Darling Square North Plot + The Square Response to Submissions (RTS) Report

14076 - SSDA10(RTS)

December 2016

WEEKEND MARKET

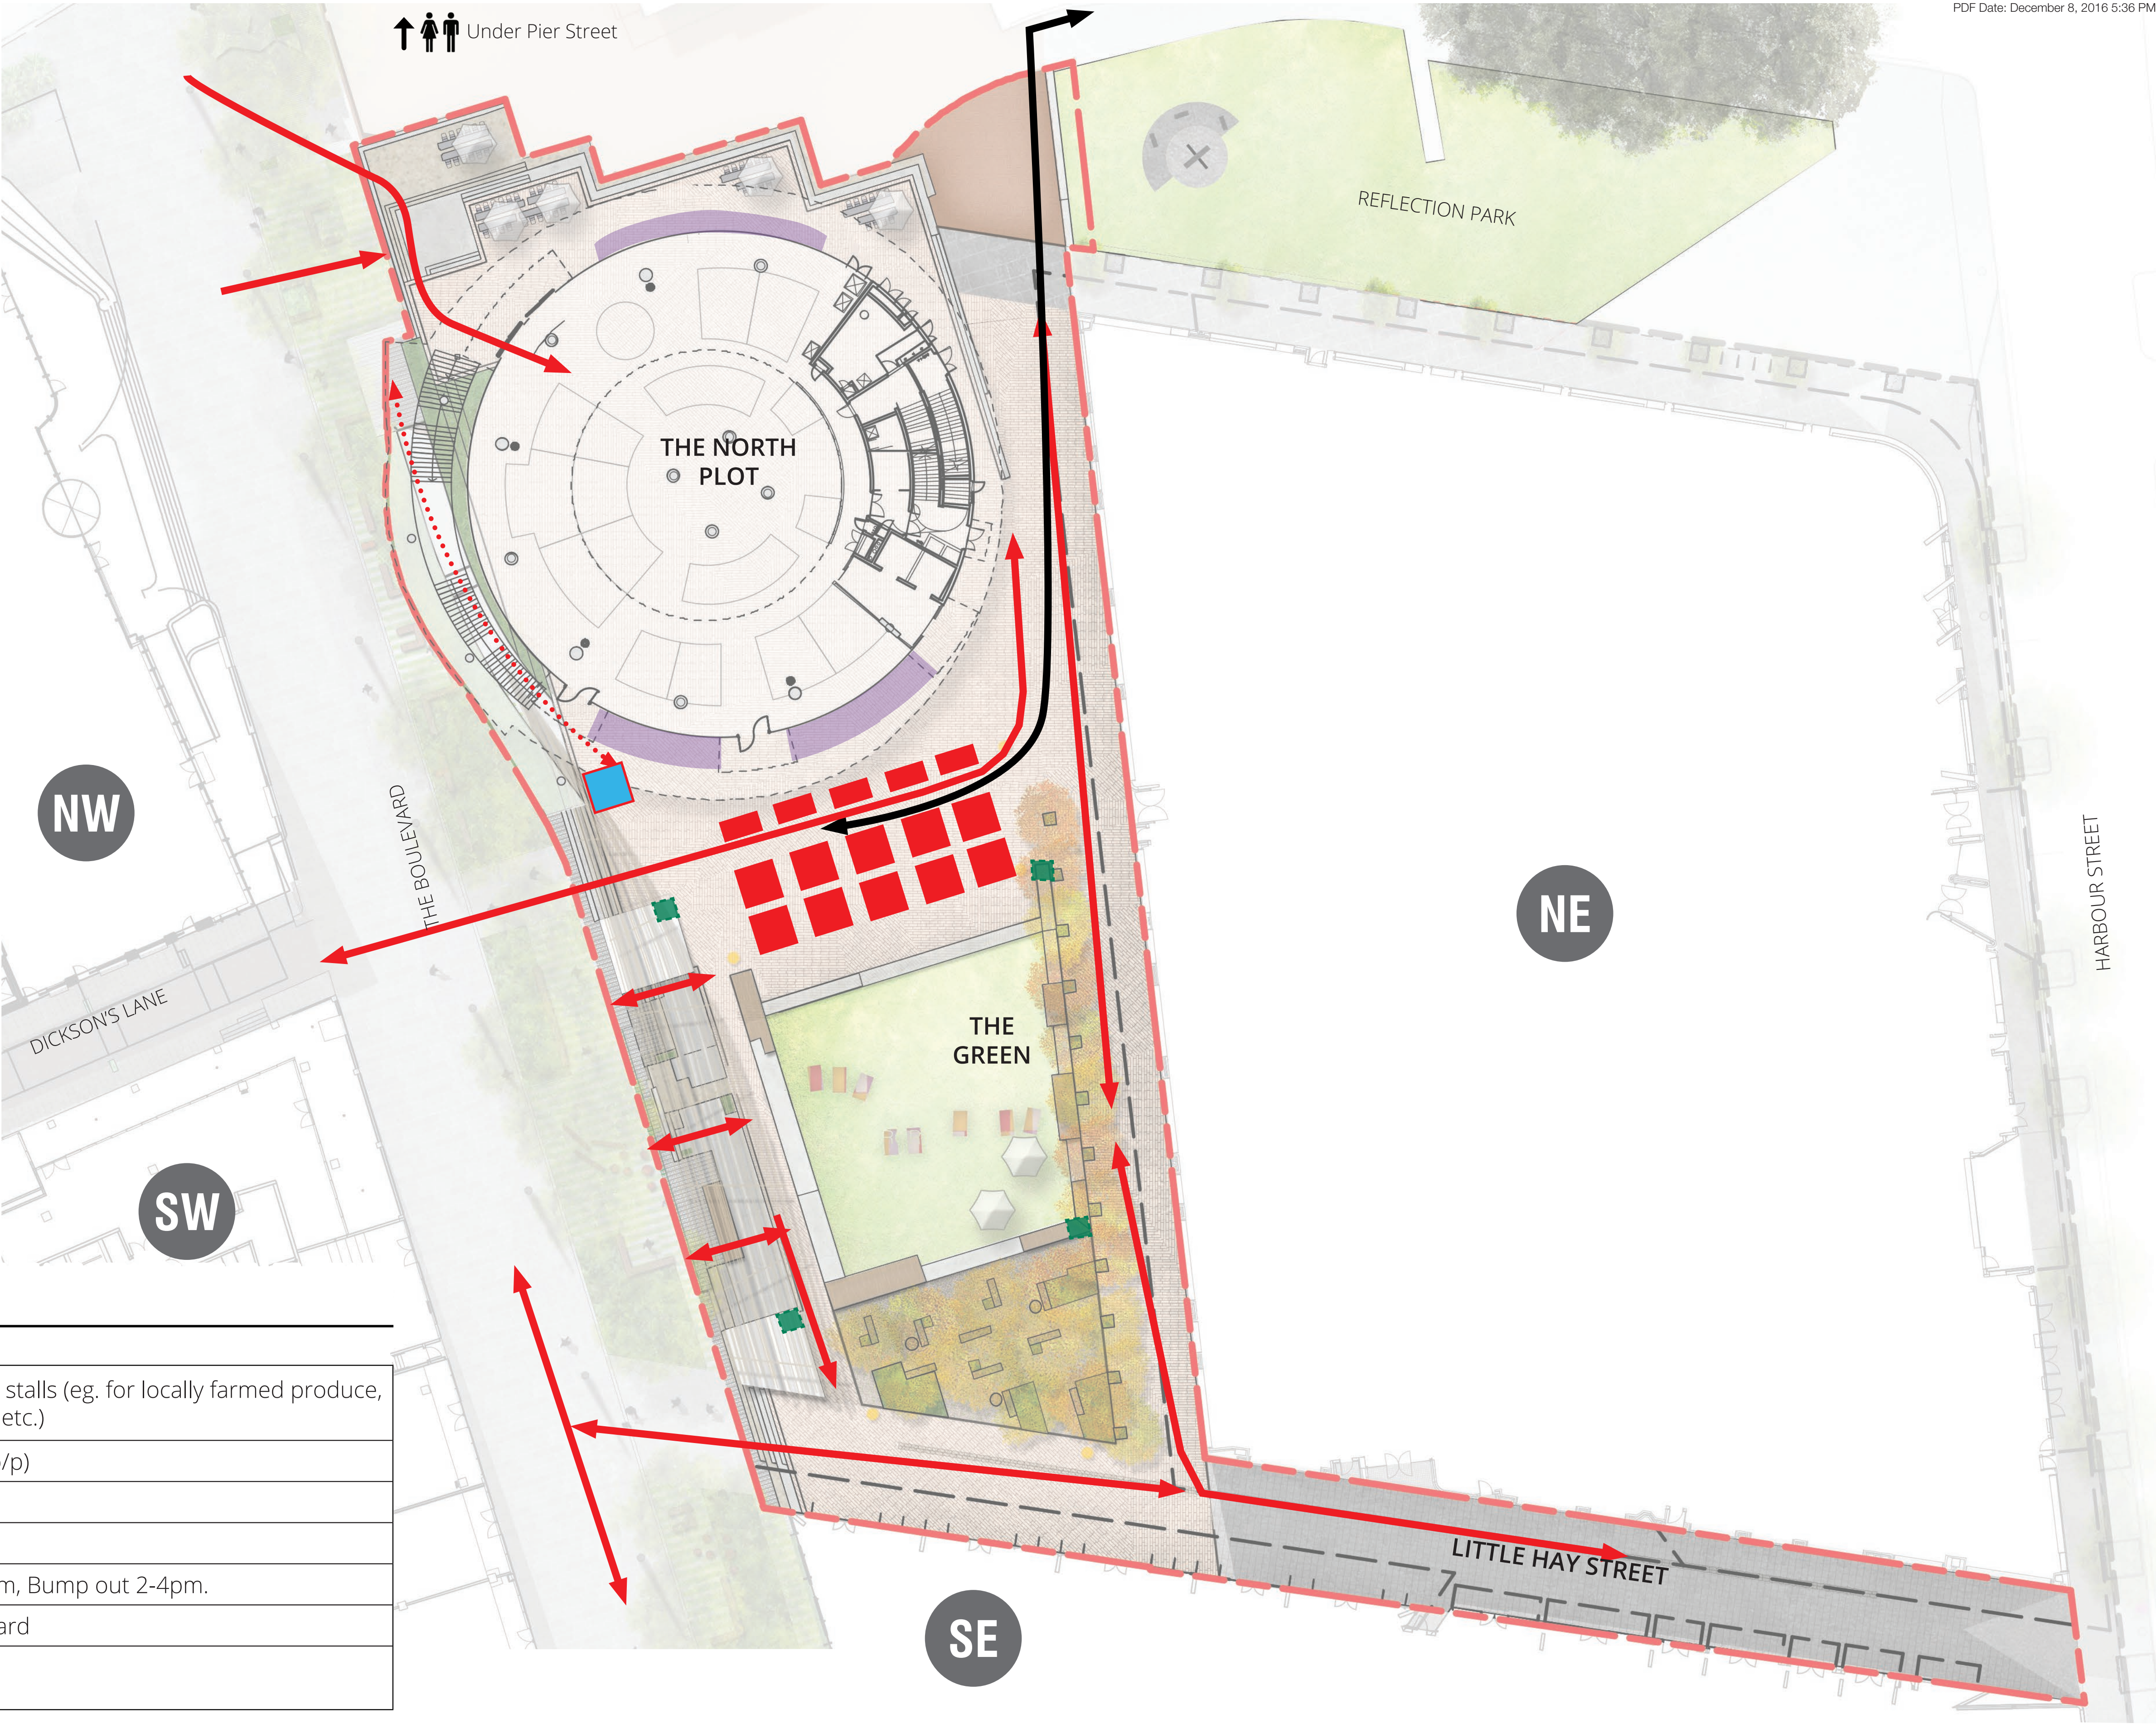
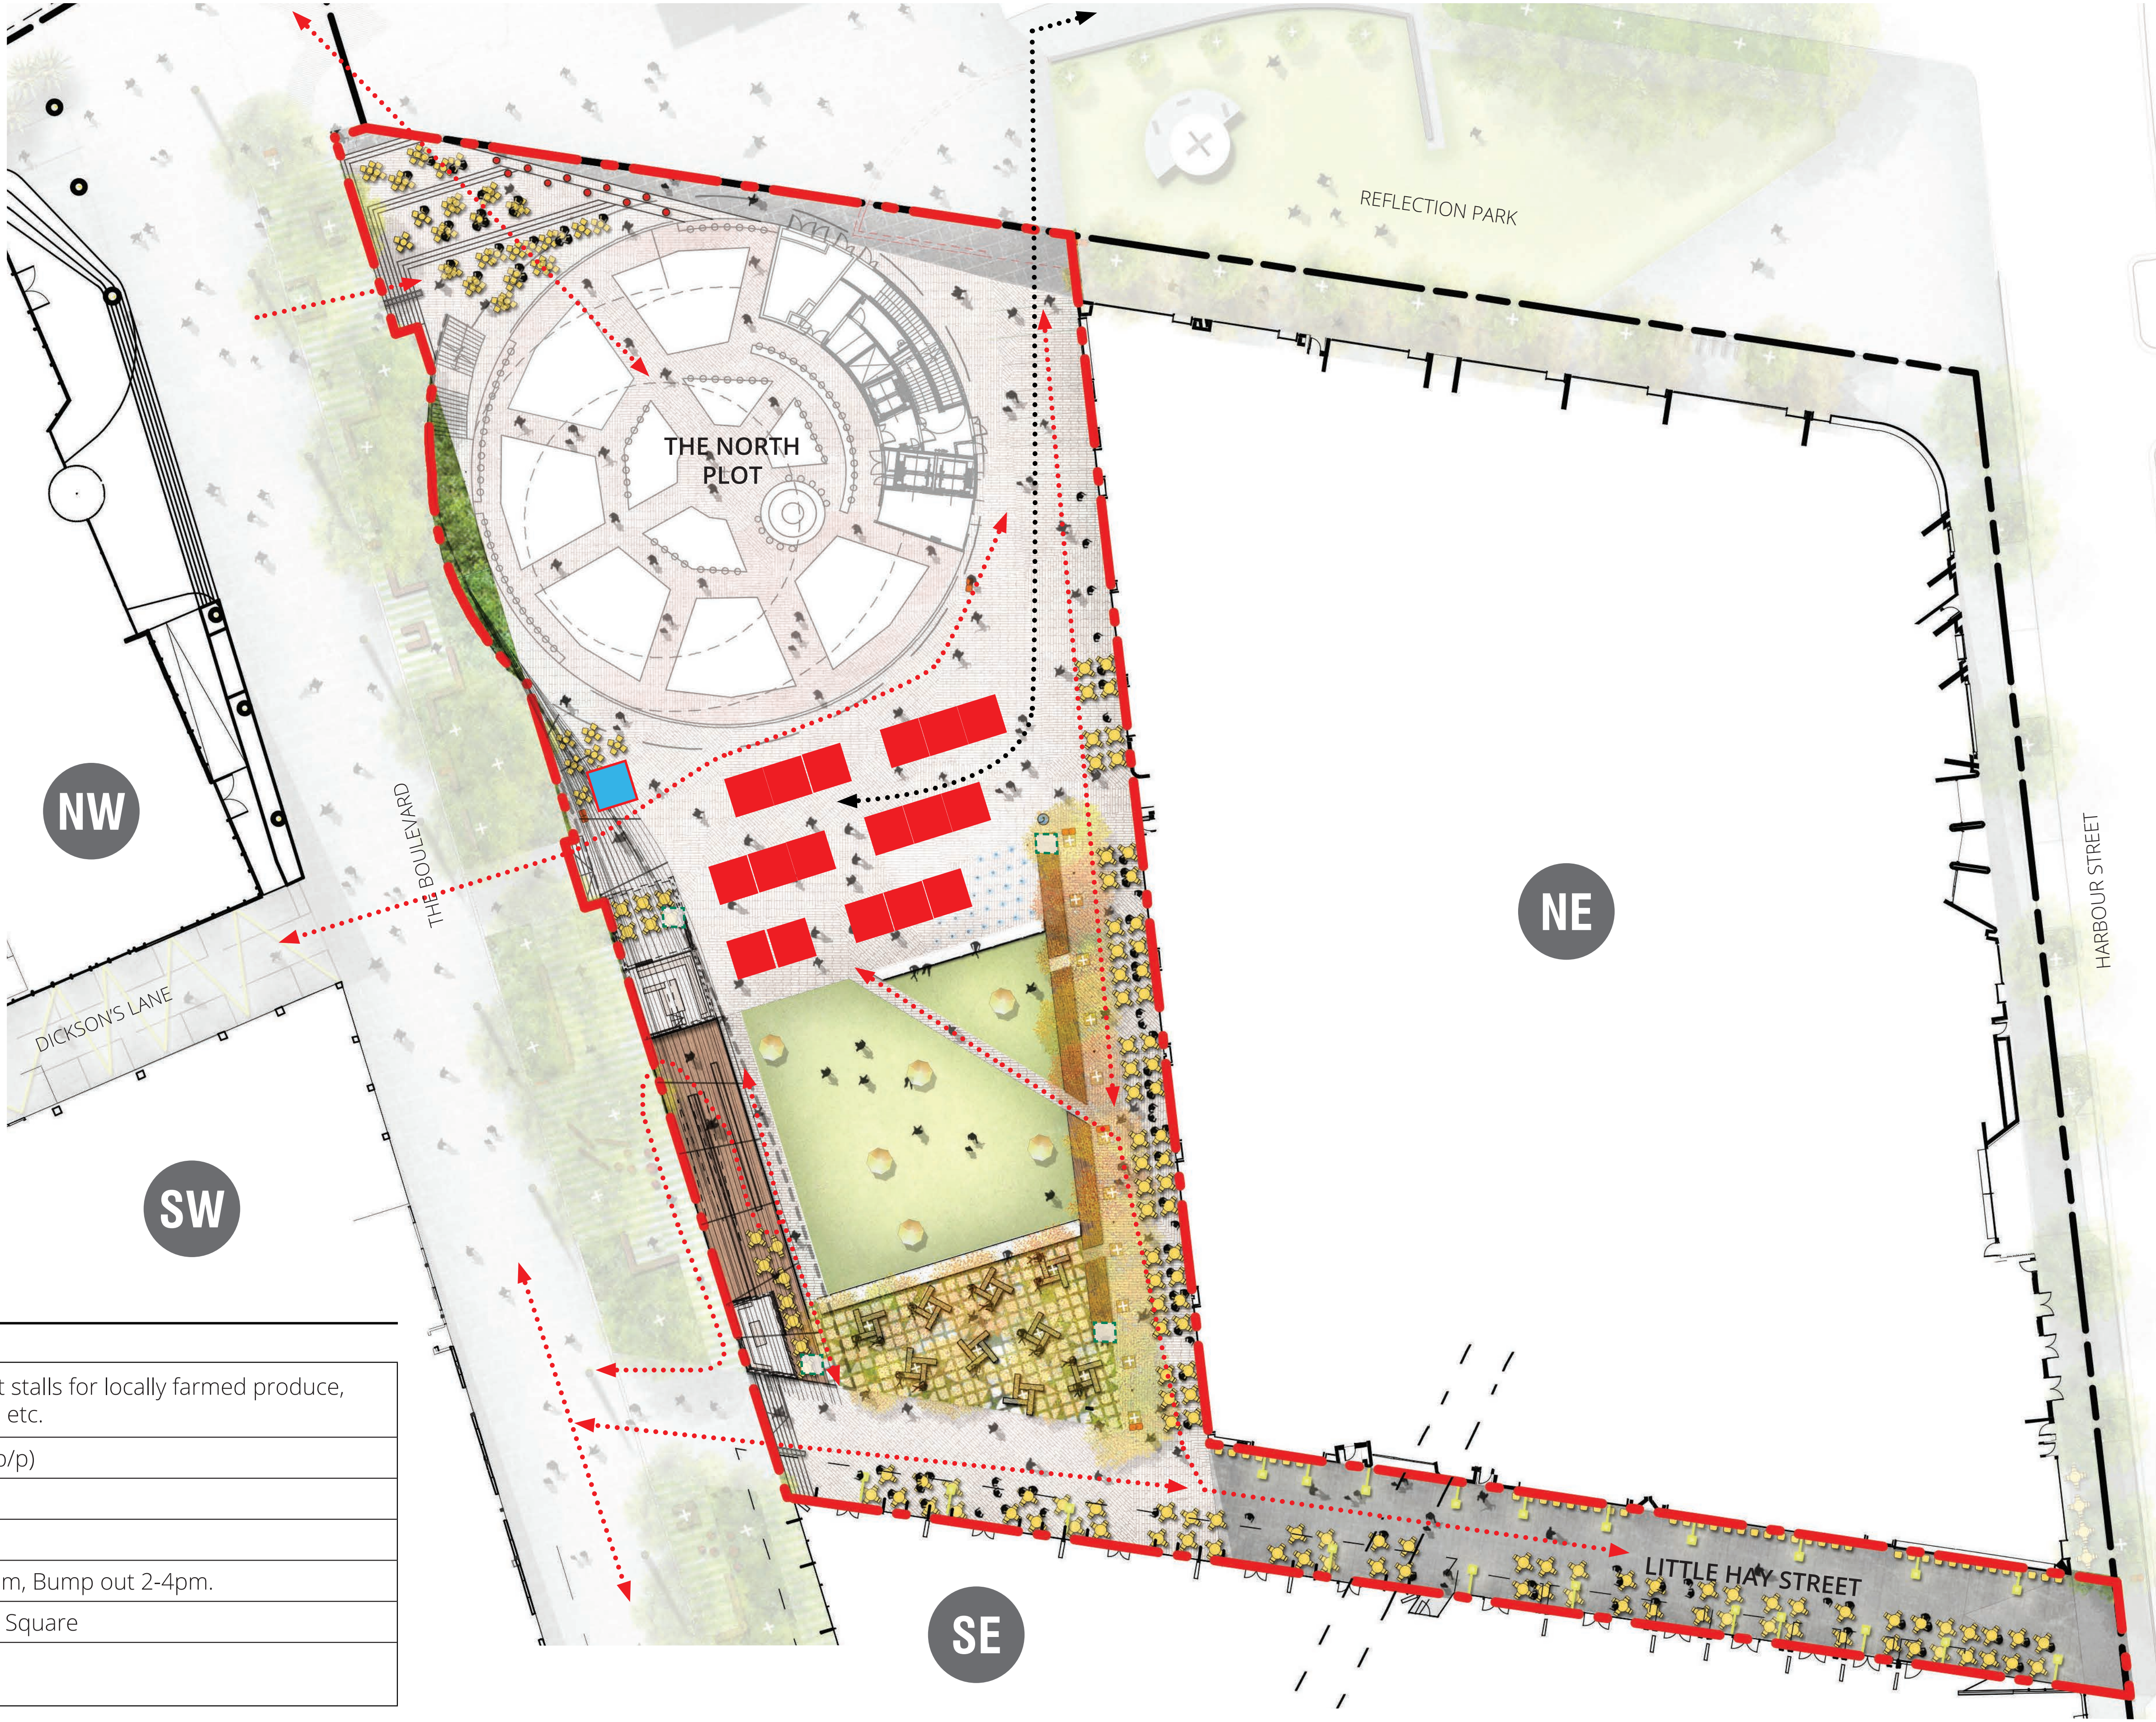
The proposed indicative layout for markets in the Square is not efficient or customer friendly in the City's experience. Market layouts should be approached in regular geometric patterns. Power supply, water supply and vehicle access should be designed accordingly.

The market layout has been further developed and is outlined in the revised DA response to submission drawings. Services overlays have also been amended and are reflected in the revised response to submission drawings.

The design provides a reasonable area for flexible-mode use by markets and events, and servicing for this purpose.

Power and water are proposed to be supplied to The Square. Refer to Arcadis' report and drawings. Refer to TTM's traffic report for vehicle servicing and access.
